Project Name: Aviation Hangar
Address: 1071 Westbrook Street
Q012
Applicant: Mark Goodwin
Planner: Matthew Grooms

Project ID: 2017-073, 2017-115
CBL: 012

RE: Staff Review Comments for 1071 Westbrook Street Aviation Hangar (2017-158) – Planning Authority Review

Project Name:	Jetport Aviation Hangar	Project ID:	(2017-158)
Project Address:	1071 Westbrook Street	CBL:	199 A001012
Applicant:	Mark R. Goodwin		
Planner:	Matthew Grooms

MAIN FLOOR PLAN
 SCALE: 3/16" = 1'-0"
 PROTECTED AREA: 9,270 SQ. FT.

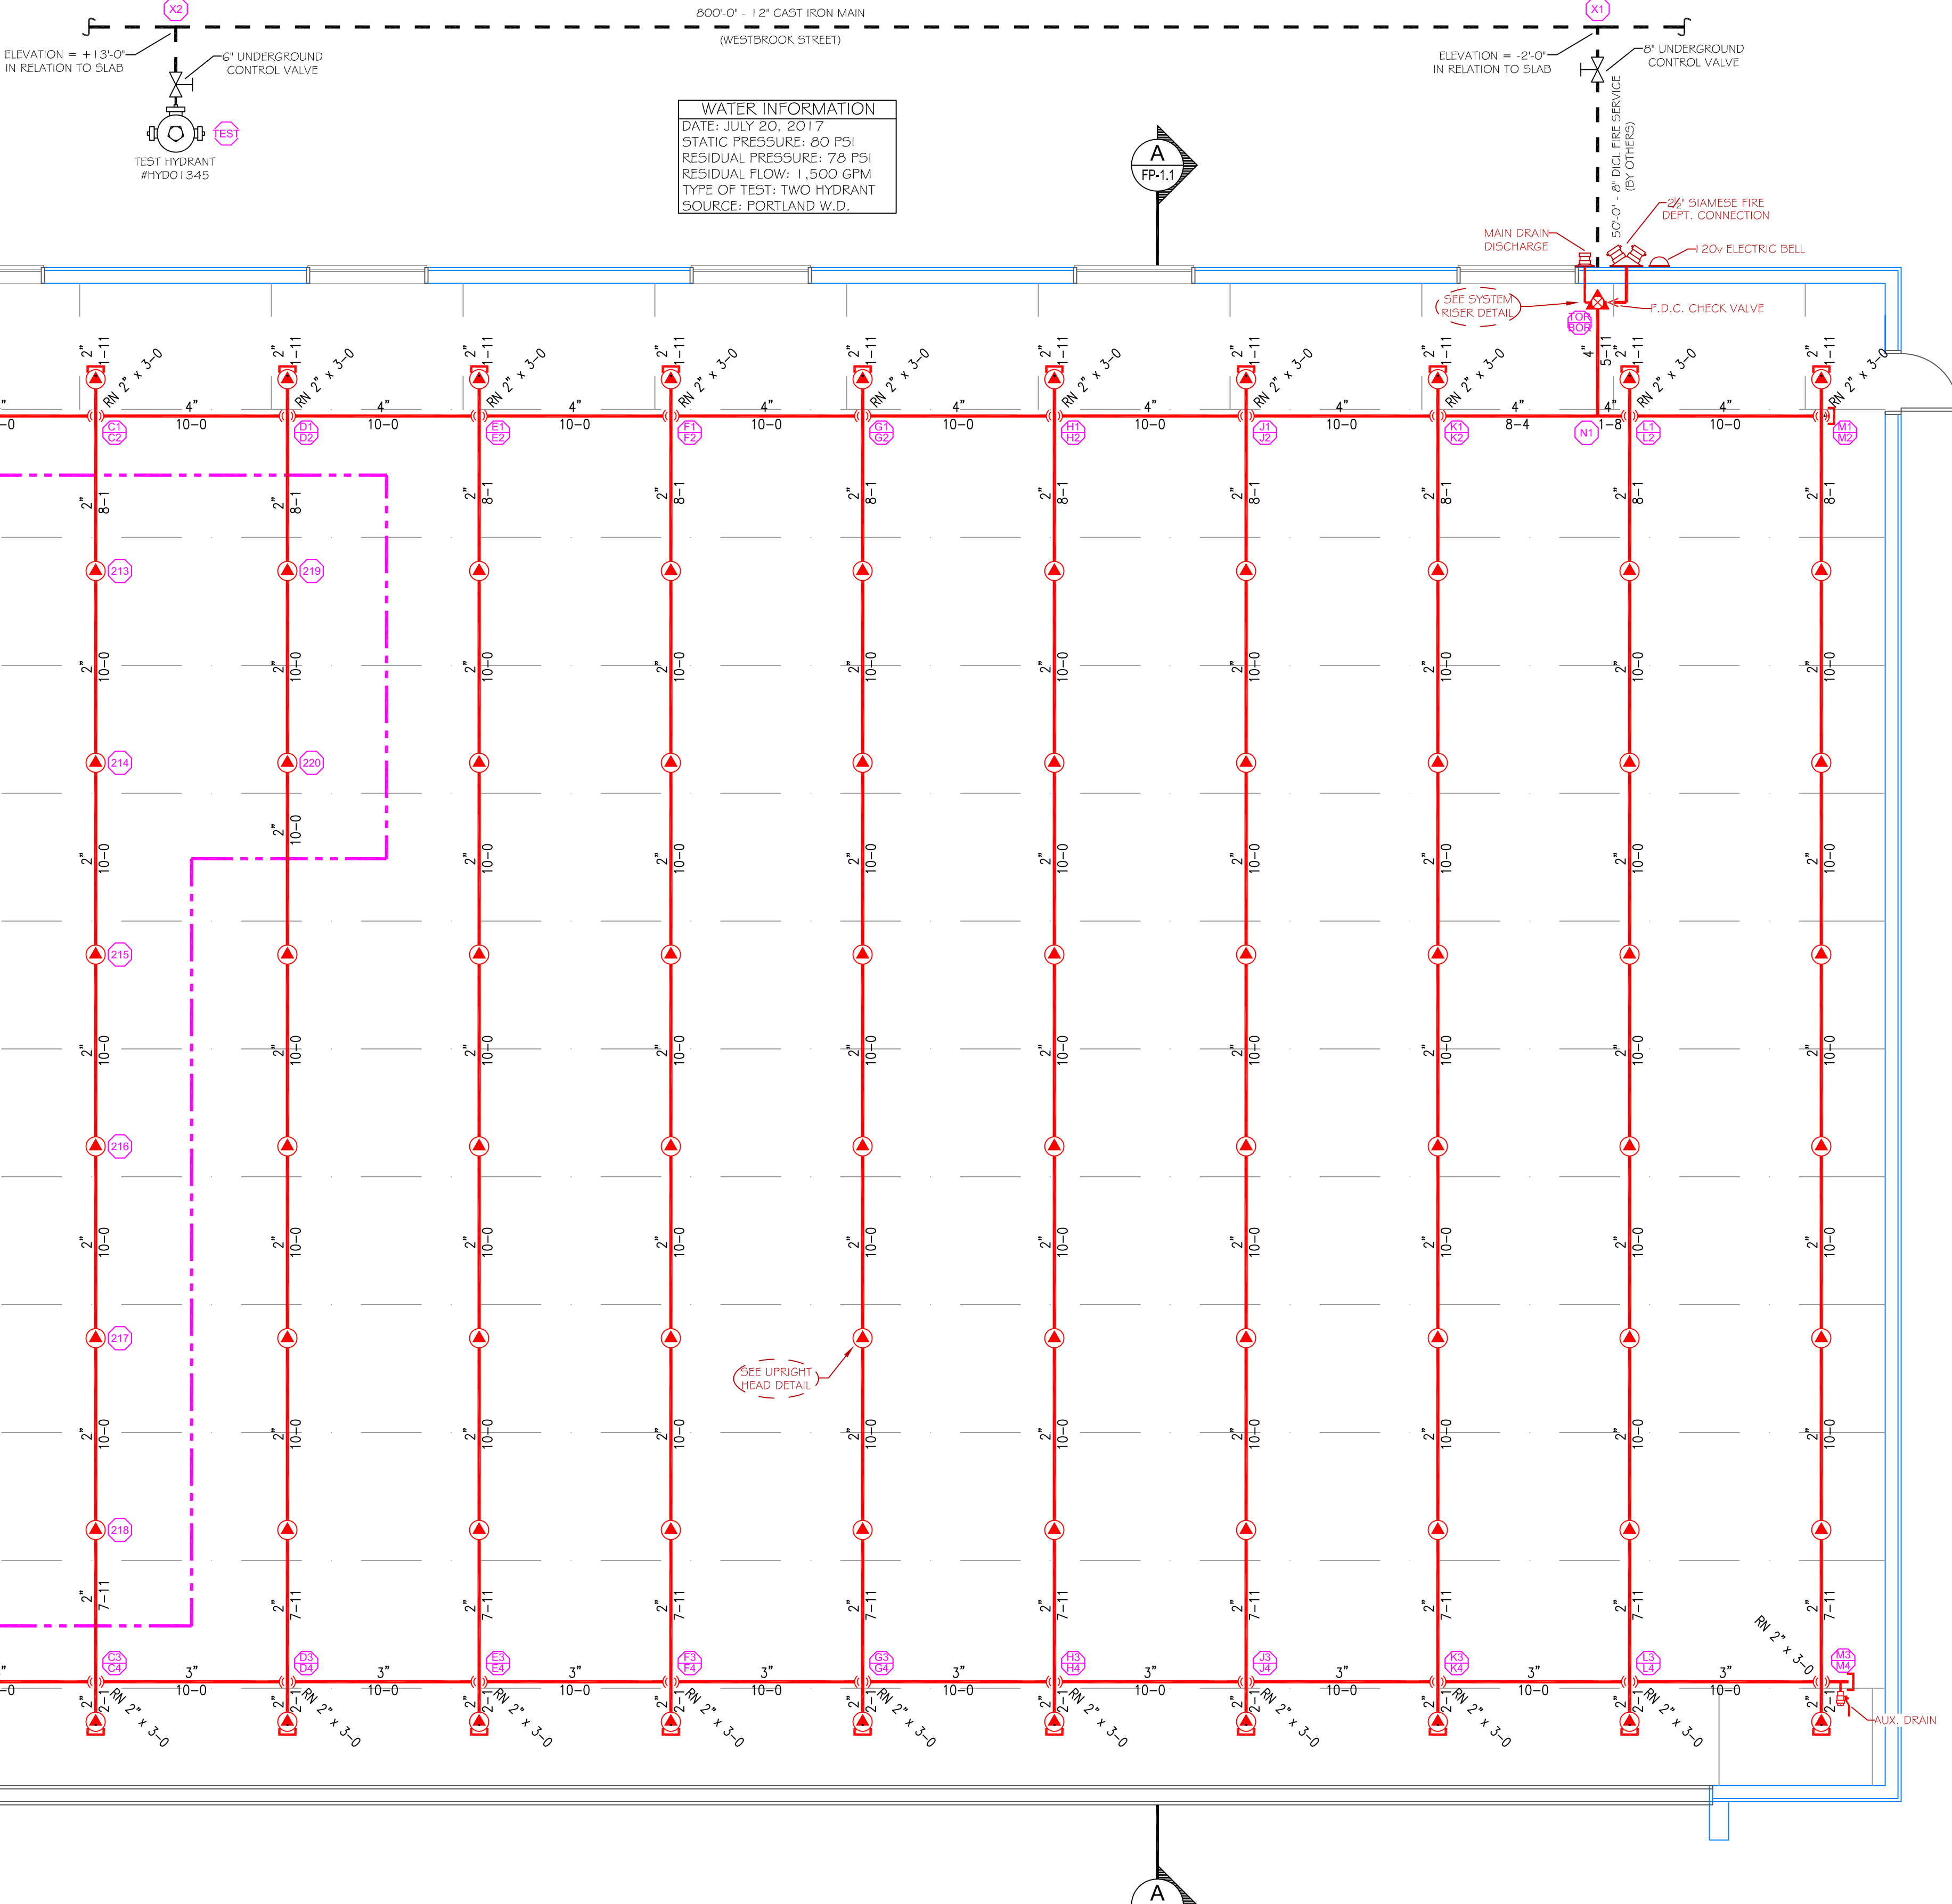
1. The new hangar will need to follow NFPA 409 Standard for Airport Hangars.
2. Fire gate #1 is our primary access to the airfield so if being used for construction then it will need to be maintained for emergency vehicles at all times.
3. Site access will be the same as this project is a replacement of the existing hangar.

- a. Indicate the location of the floor drain and crushed stone drip strip on the Grading & Utility Plan,
 - b. Work with the Department of Public Works to approve the submitted wastewater capacity application and proposed configuration,
 - c. Provide a written response and if necessary revised plan indicating how roof drainage shall be managed
3. The applicant shall provide a photometric plan demonstrating compliance with the City's standards for site lighting as listed in Section 12 of the Technical Manual; and
 4. The applicant shall provide an 'Ability to Serve' letter from the Portland Water District for the proposed fire service; and
 5. The proposed hangar will need to follow NFPA 409 Standards for Airport Hangars; and
 6. Fire Gate #1 shall be maintained for emergency vehicles at all times during construction.
